88 Preble Street - Final Traffic Comments

Hi Barbara – I have reviewed the most current project information and offer the following final traffic comments.

DRAWN BY SHEET TITLE  
**Off-Street Parking Plan**

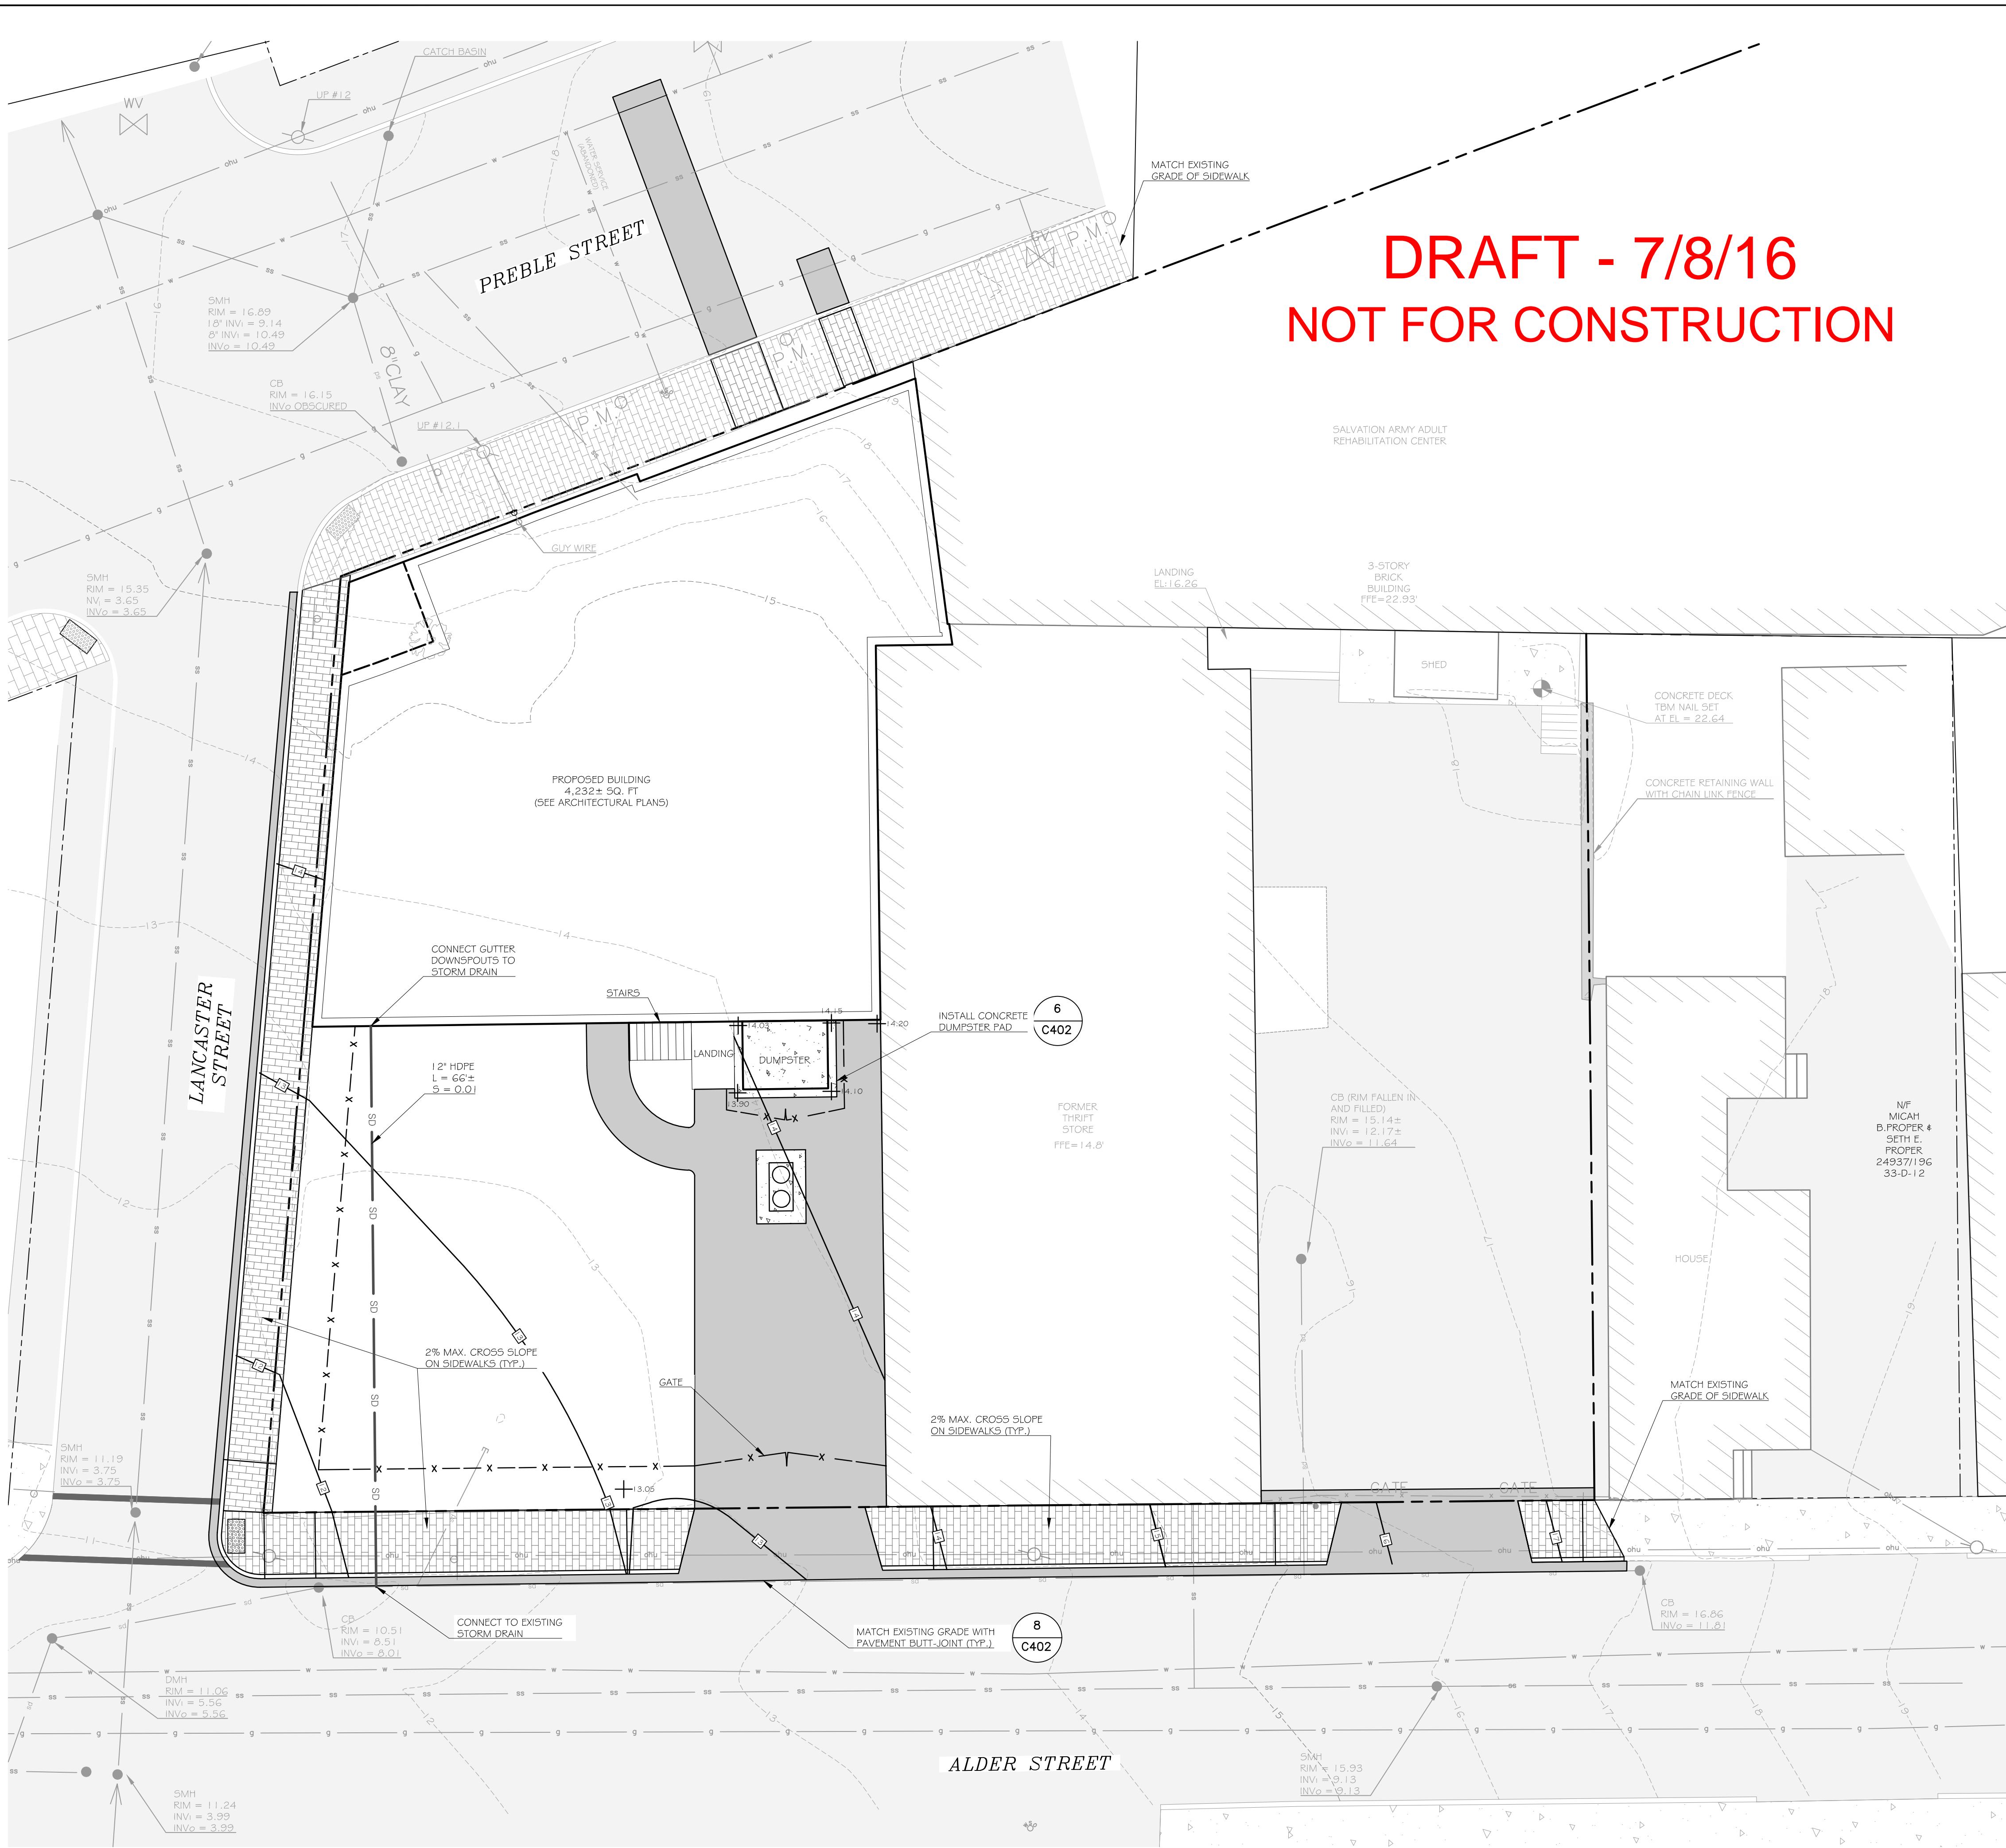
- I find the existing parking lot layout to be acceptable and support a waiver from the City's technical standards for parking aisle width.
- Bruce Hyman has provided design direction on the sidewalk ramps. The plans should be revised to reflect Bruce's comments.
